From: Clare Dales
Sent: 30 January 2018 16:42
To: Simon Davis
Subject: RE: Substitute plans Forge House

From: Susan Leeson [REDACTED]
Sent: 30 January 2018 08:12
To: Simon Davis
Subject: Substitute plans Forge House

Please find revised plans for Forge House to address concerns as discussed. The amended plans have made provision to retain as much of the rear walling as possible, retaining the historic context.

Location and Site Plans

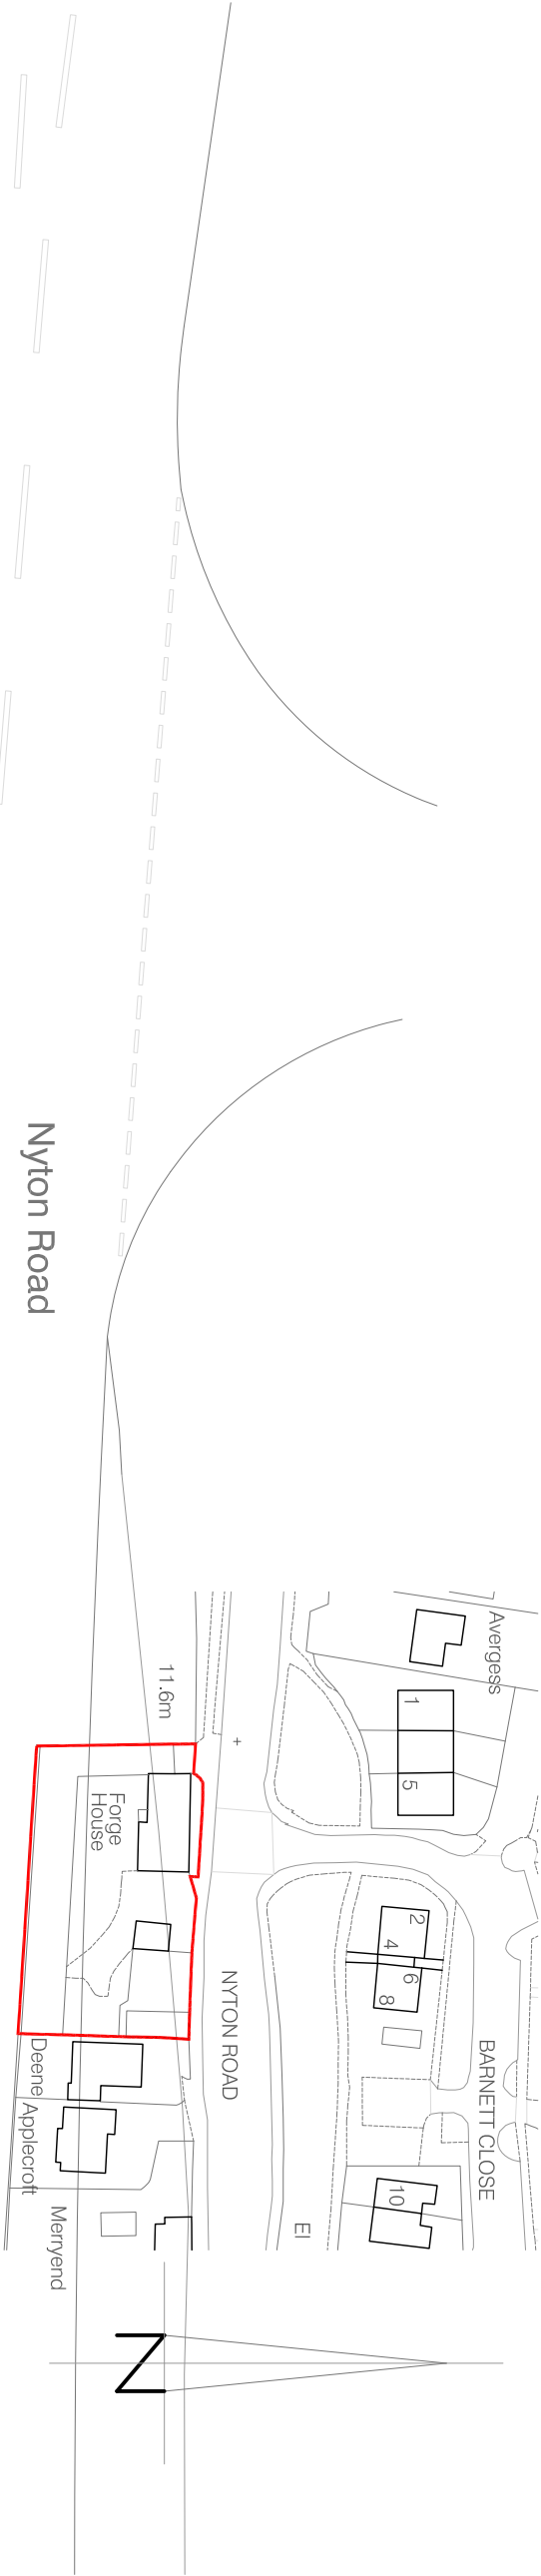
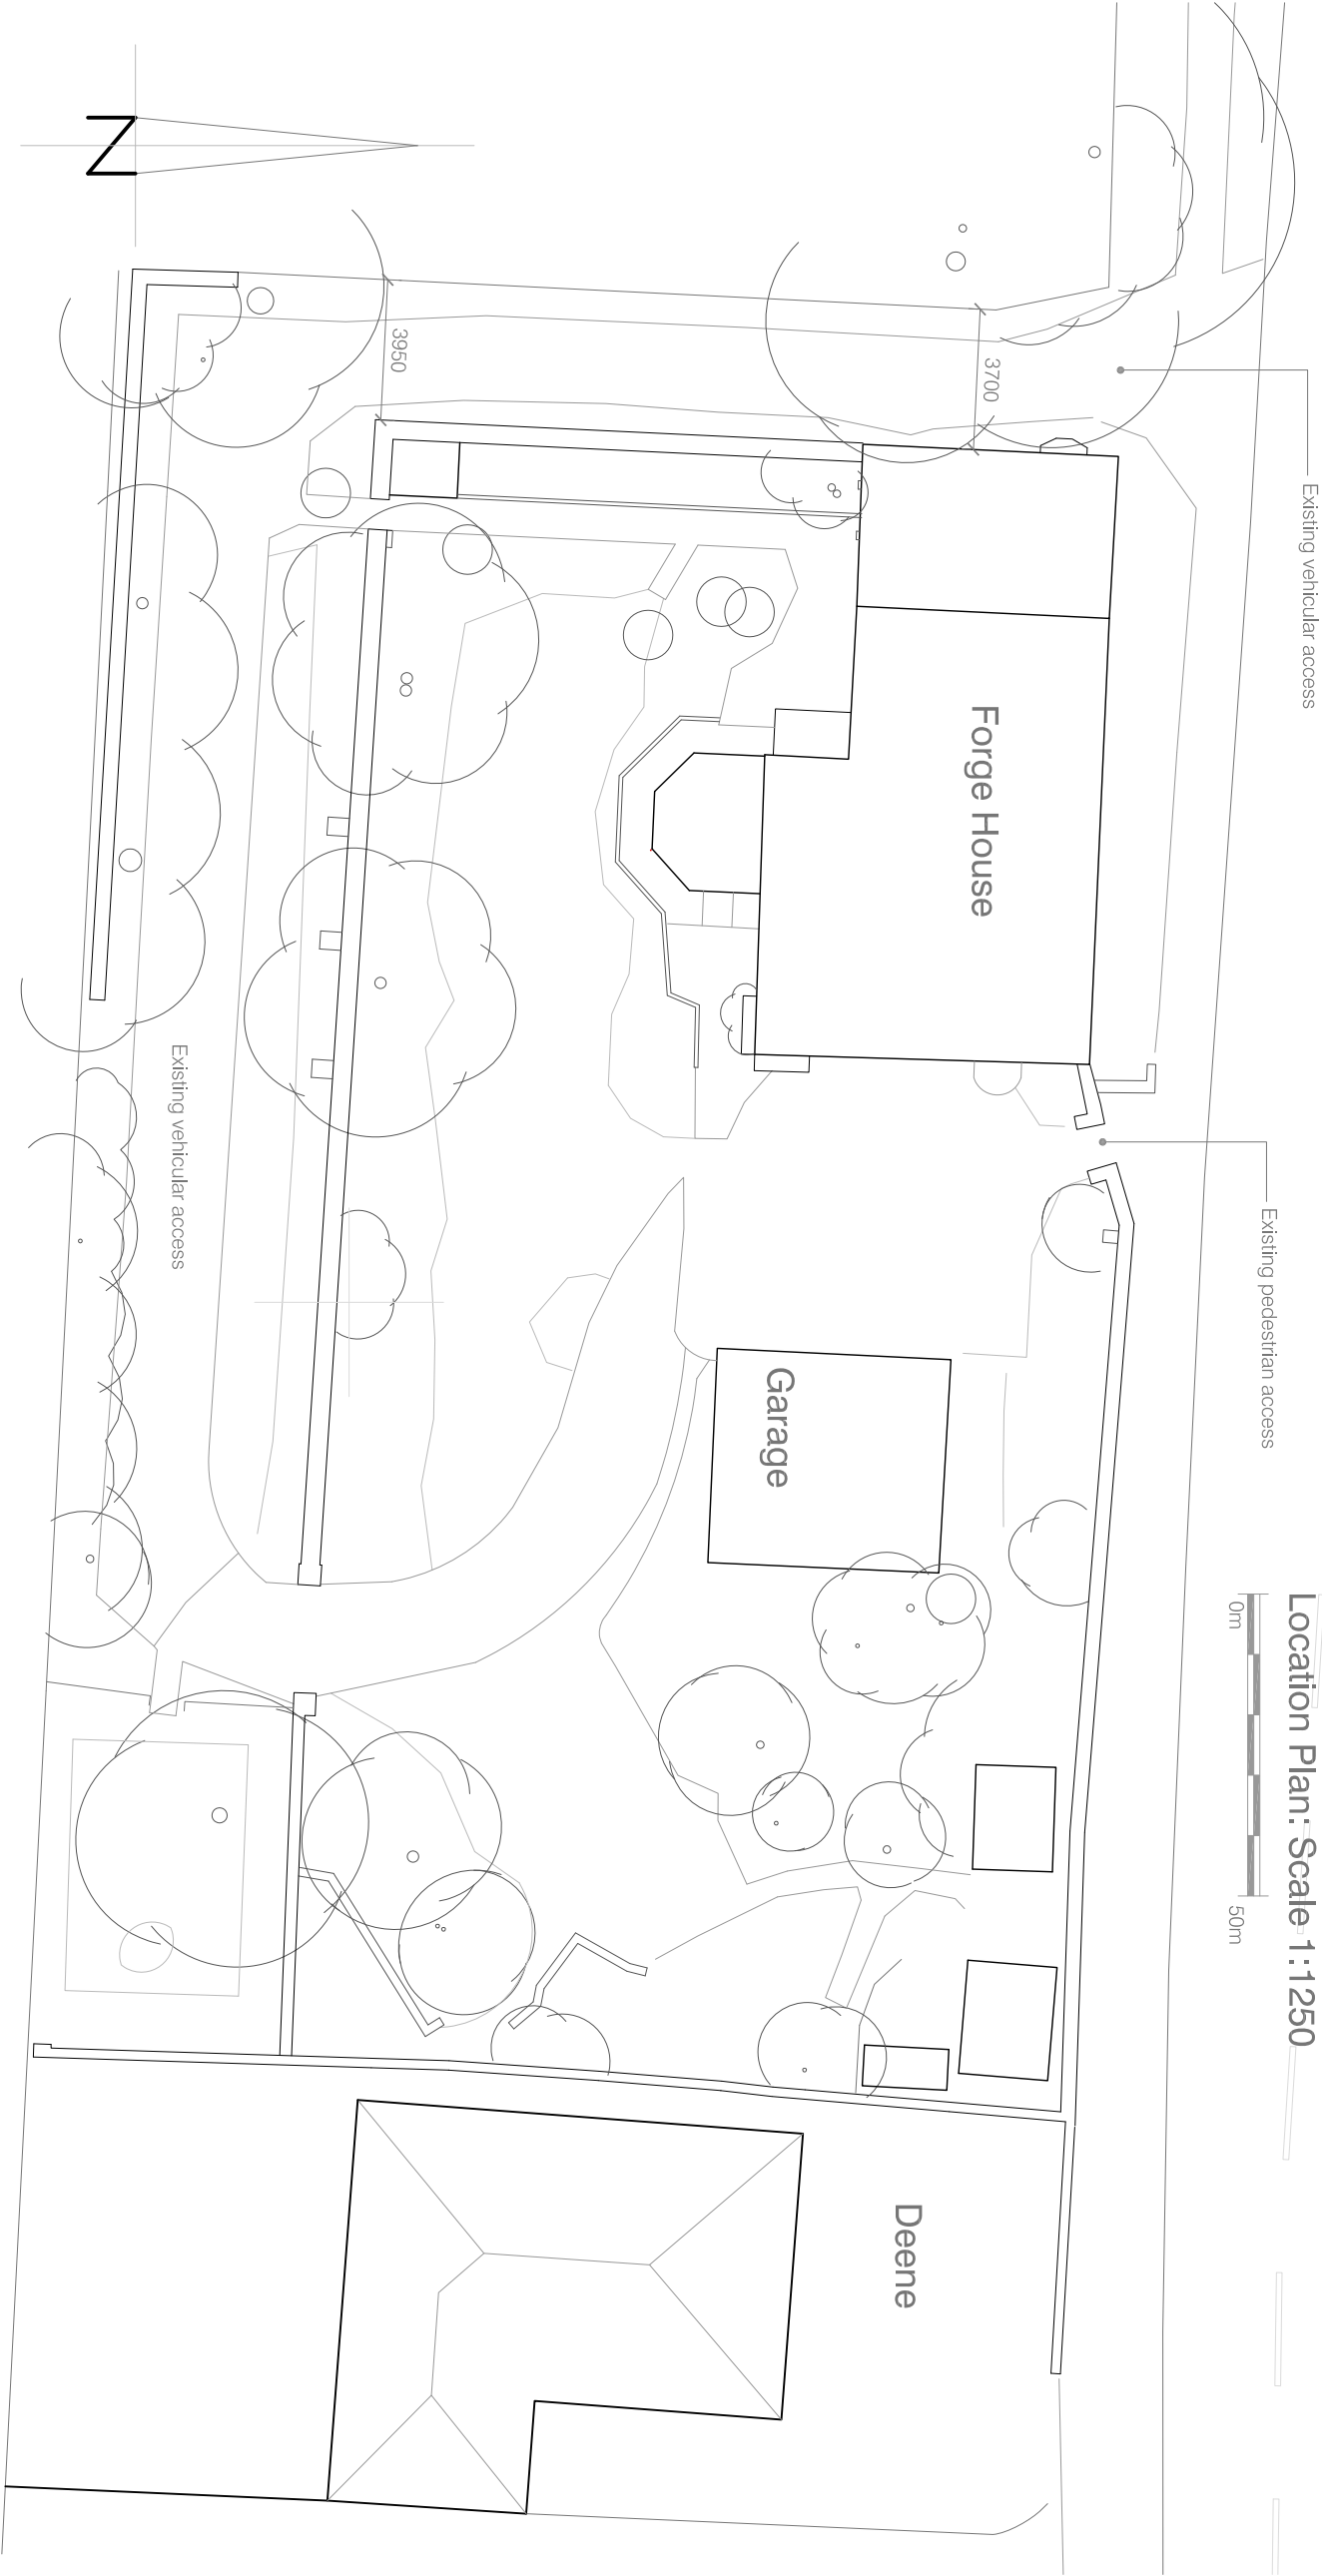
I agree that I think we have already discussed the elevational changes. With regard to the alterations to the historic wall, the revised plans still show a significant amount of removal, resulting in a) significant loss of fabric and b) visual fragmentation of the wall.

Clare – for you to reconsider please. Looks like they are retaining sections of flint walls in the new rear gardens and also narrowing the car entrance into the back of the existing dwelling. Also note elevational changes which I think we have already spoken about.
